RE: NM SPORTS AND WELLNESS (C-13/D12B)
(9190 Coors Blvd NW)
ENGINEERS CERTIFICATION FOR CERTIFICATE OF OCCUPANCY
ENGINEERS STAMP DATED 3/24/2000
ENGINEERS CERTIFICATION DATED 2/25/2003

**RE: NEW MEXICO SPORTS & WELLNESS/RIVERPOINT (SAN MIGUEL PHASE III).
(C13-D12B). DRAINAGE REPORT AND GRADING PLAN FOR BUILDING
PERMIT AND GRADING PERMIT APPROVALS. ENGINEER'S STAMP DATED
MARCH 24, 2000.**

**RE: SAN MIGUEL APARTMENTS - PHASE 111 (C13-D12B) DRAINAGE REPORT
FOR BUILDING PERMIT APPROVAL. ENGINEER'S STAMP DATED JUNE
19, 1997.**

RE: SAN MIGUEL APARTMENTS - PHASE 111 (C13-D12B) DRAINAGE REPORT FOR SITE DEVELOPMENT PLAN FOR BUILDING PERMIT APPROVAL, FOUNDATION PERMIT APPROVAL, BUILDING PERMIT APPROVAL, AND GRADING PERMIT APPROVAL. ENGINEER'S STAMP DATED 9-25-95.

GRADING & DRAINAGE
PLAN, PHASE III
SAN MIGUEL APARTMENTS
TRACTS 1 THRU 3-A, RIVER POINT
ALBUQUERQUE, NM

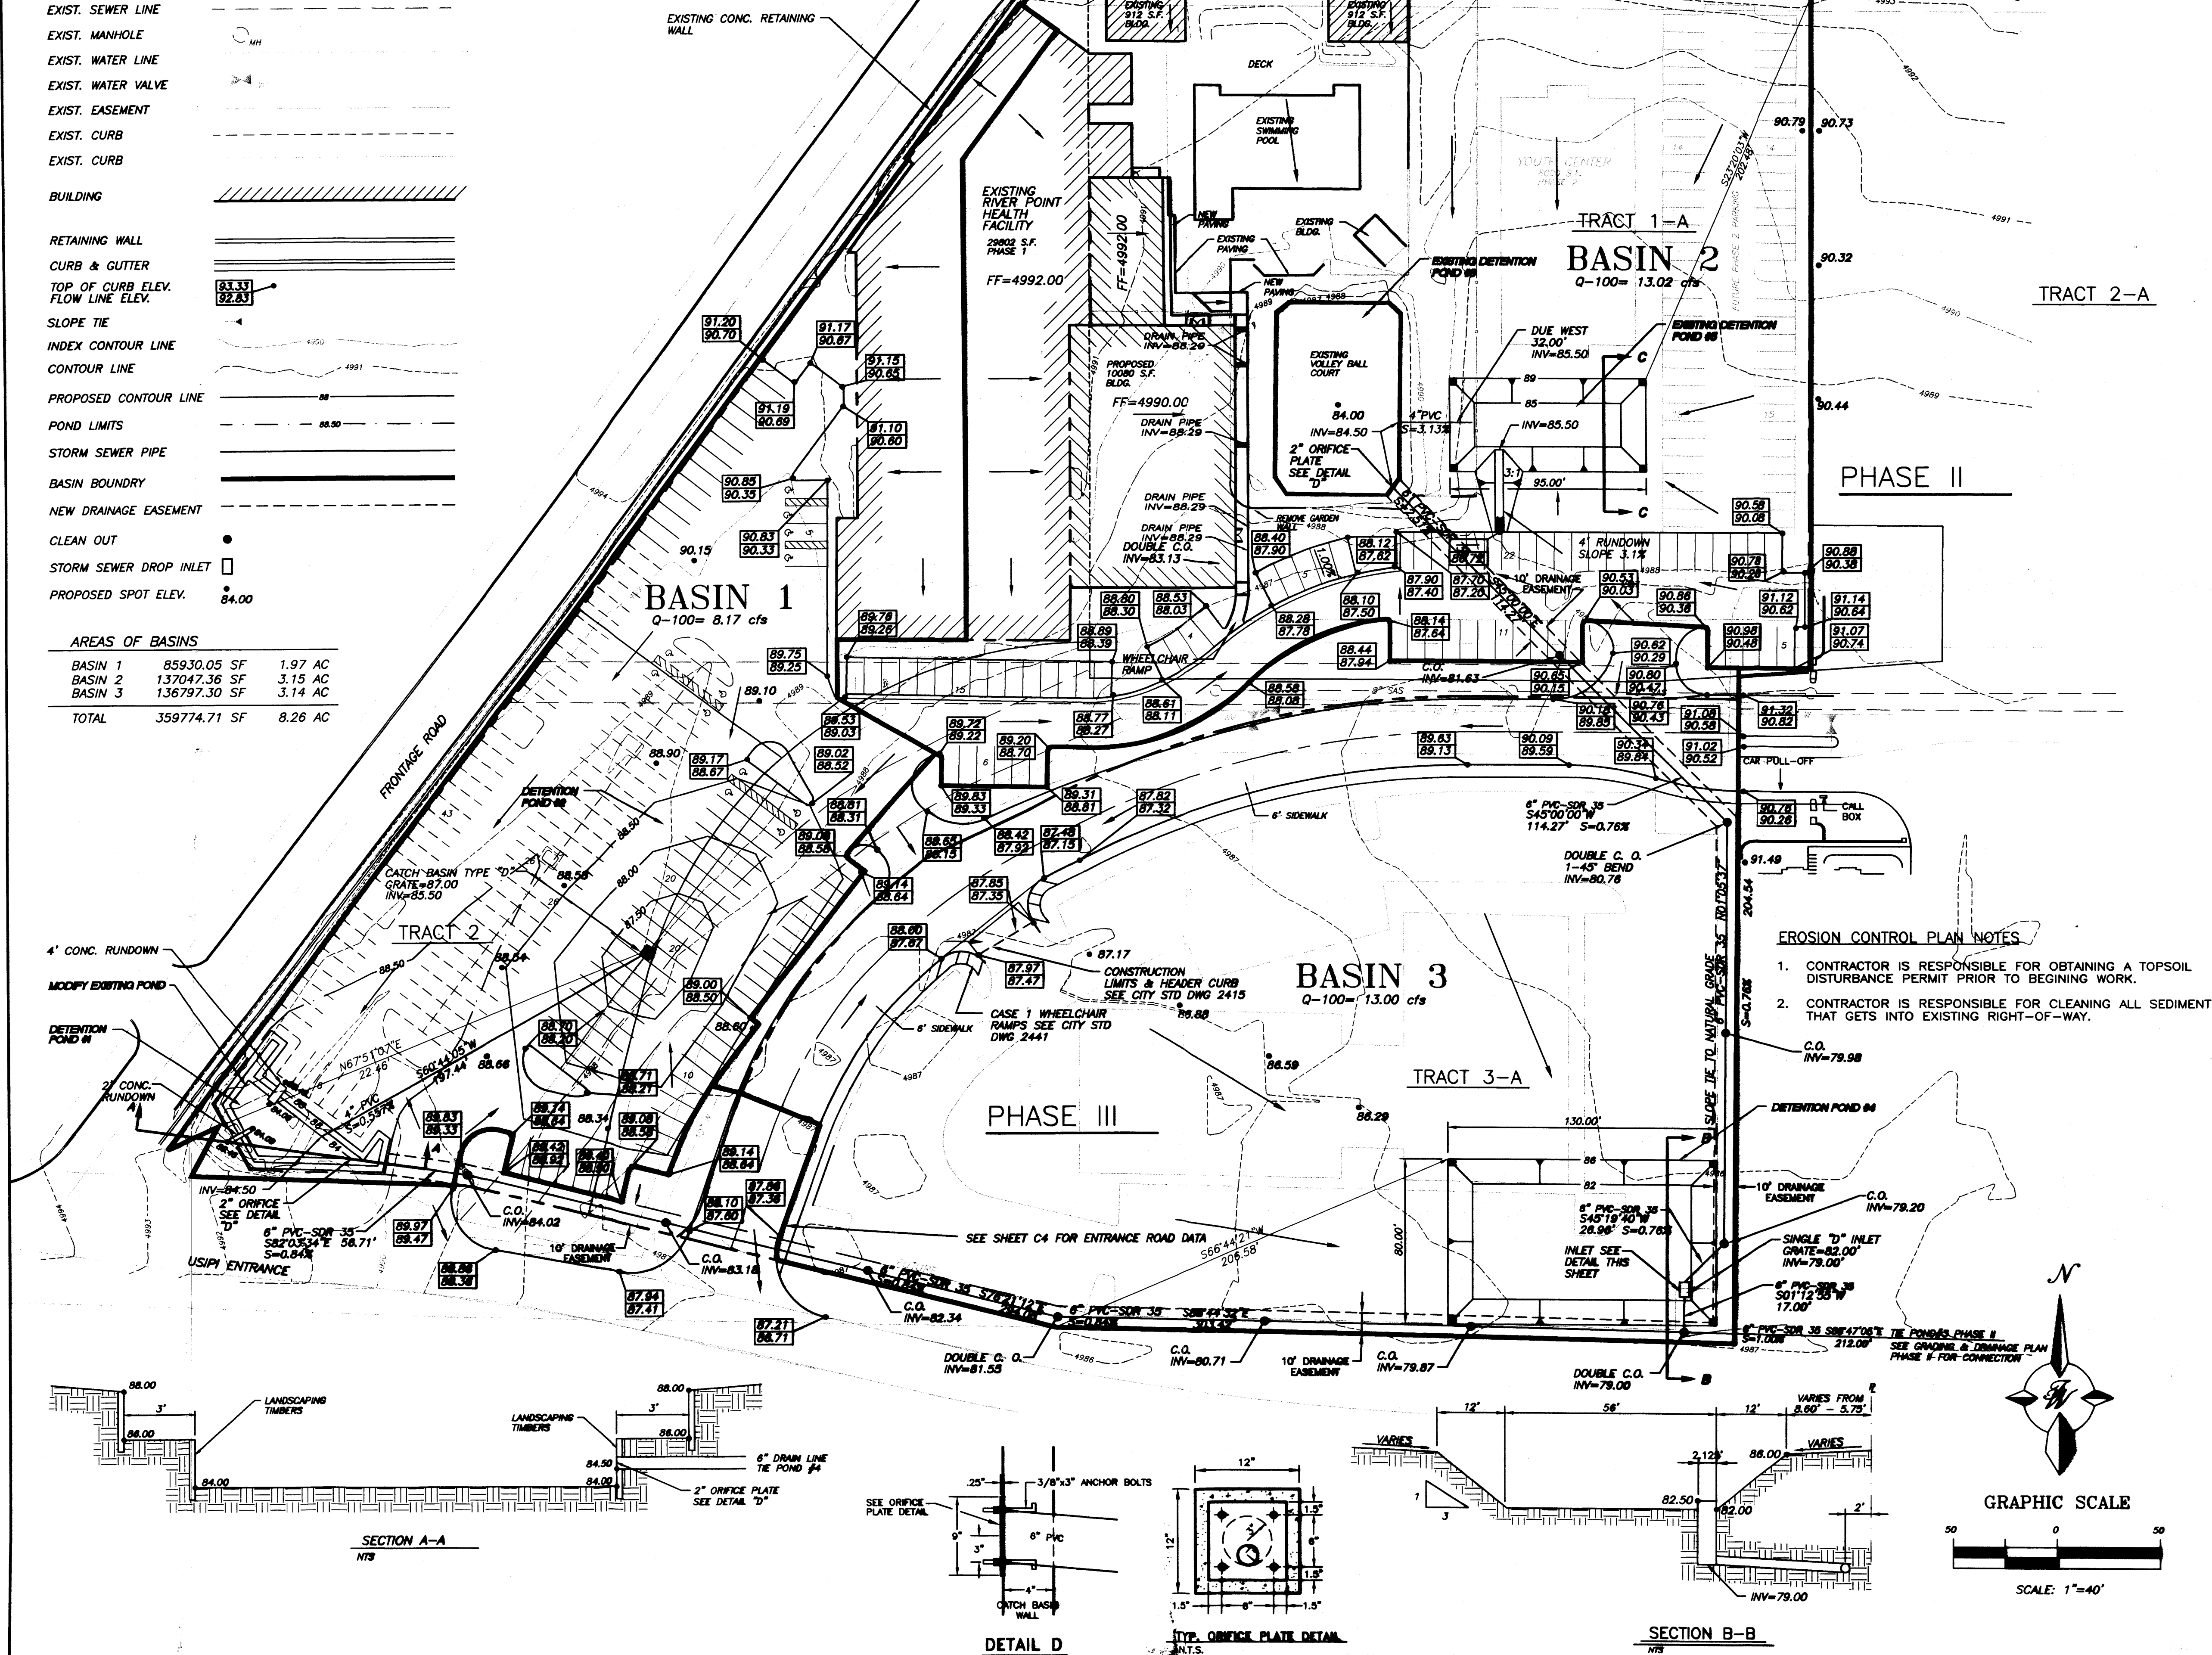
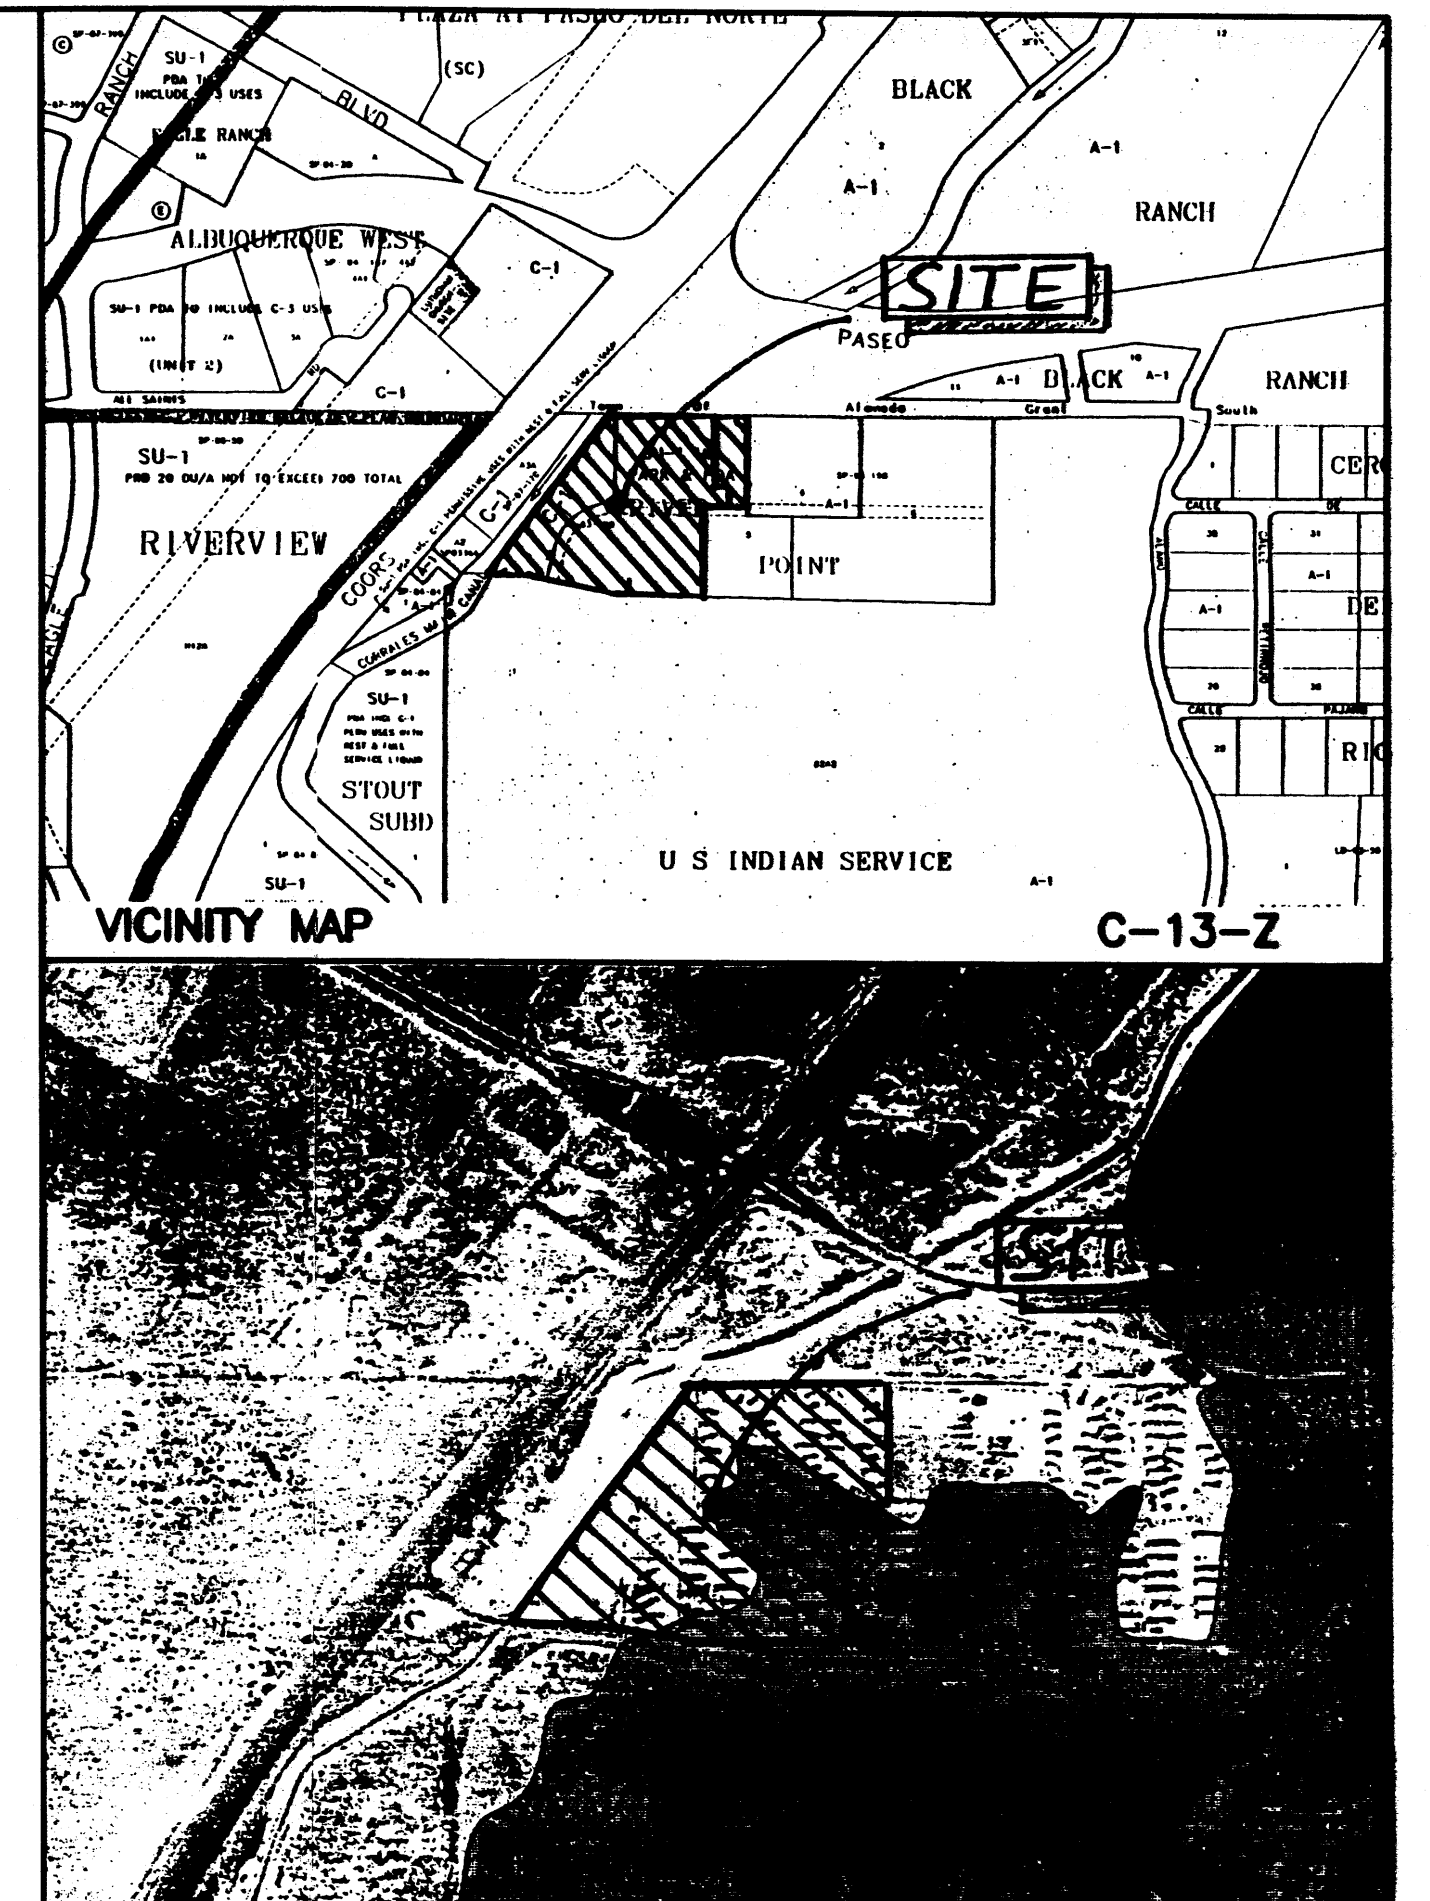
Please be aware that the type "D" inlet you propose for pond #4 may
be a maintenance problem. The owner is responsible for maintenance
of all on-site storm drain facilities.

1. What is the flow rate leaving the 2 foot concrete rundown in pond #1? Do you have free discharge from this pond to SIPI?
2. Please provide elevations for the 2 foot and the 4 foot concrete rundown in pond #1.
3. Is the area between SIPI and pond #1 landscaped to control sediment onto SIPI?
4. How does pond #3 in Basin #2 drain? It appears that pond #5 drains to pond #3 and retains 1.5 feet of water before pond #3 backflows to pond #5. Please clarify.
